NORTH FALLS OFFSHORE WIND FARM

Appendix G4.1 to the Natural England Deadline 4 Submission

**Natural England's Lesser Black Backed Gull (LBBG) Compensation Advice on the
Applicant's Deadline 1 Documents [REP1-018, REP1-020 and REP1-058]**

25 April 2025

Figure 3 LBBG Compensation short-listed sites at the AOE SPA LBBG search area

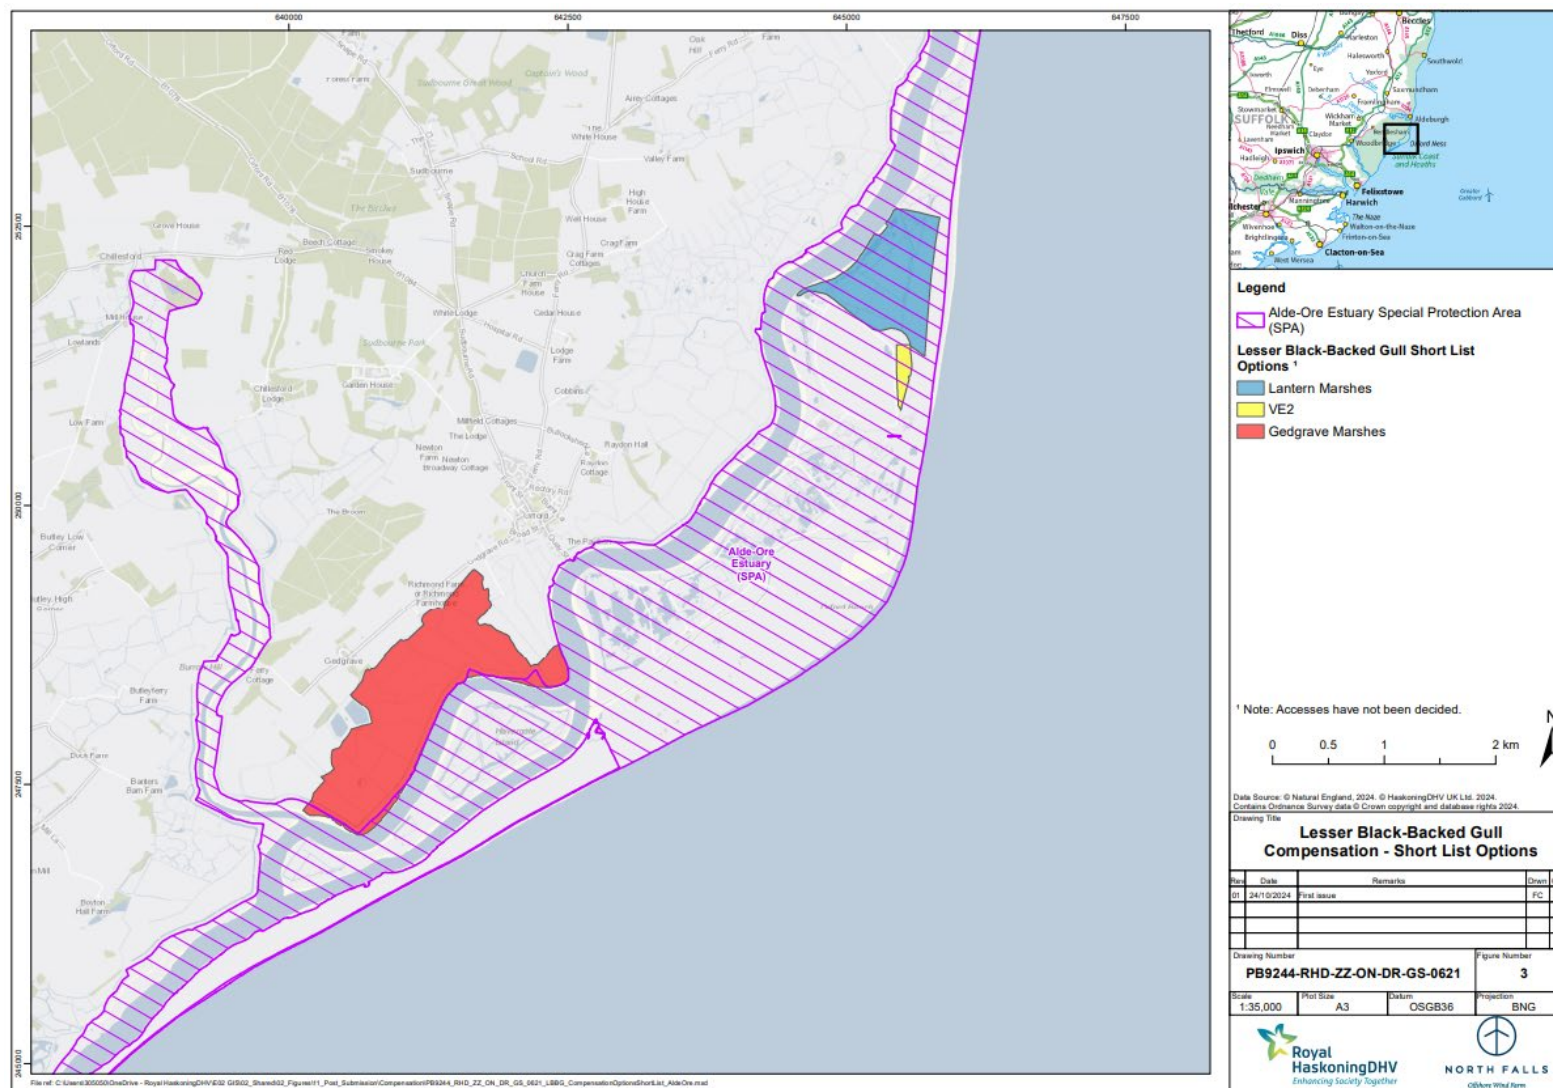
| 3 | Section 8.2.1 & 8.2.2 | <p>The Applicant has short listed Lantern Marshes and Gedgrave Marshes. We note that potential collaboration with other projects is thought to be feasible here. Natural England consider both sites to be viable options in principle and are supportive of continued development and detailing of both options in order to determine whether they are suitable and deliverable in practice.</p> | <p>Natural England advise that any supporting evidence should be submitted into Examination to demonstrate the Applicant’s ability to secure these sites for the delivery of compensatory measures.</p> |

| | | With respect to Lantern Marshes, the Applicant highlights that <i>“There have been positive discussions between the Applicant and the National Trust in respect of this site”</i> , although no substantive evidence has been submitted into the Examination to demonstrate that this site can be secured. This also applies to Gedgrave Marshes where the Applicant states, <i>“discussions between the Applicant and landowner are progressing”</i> . | |
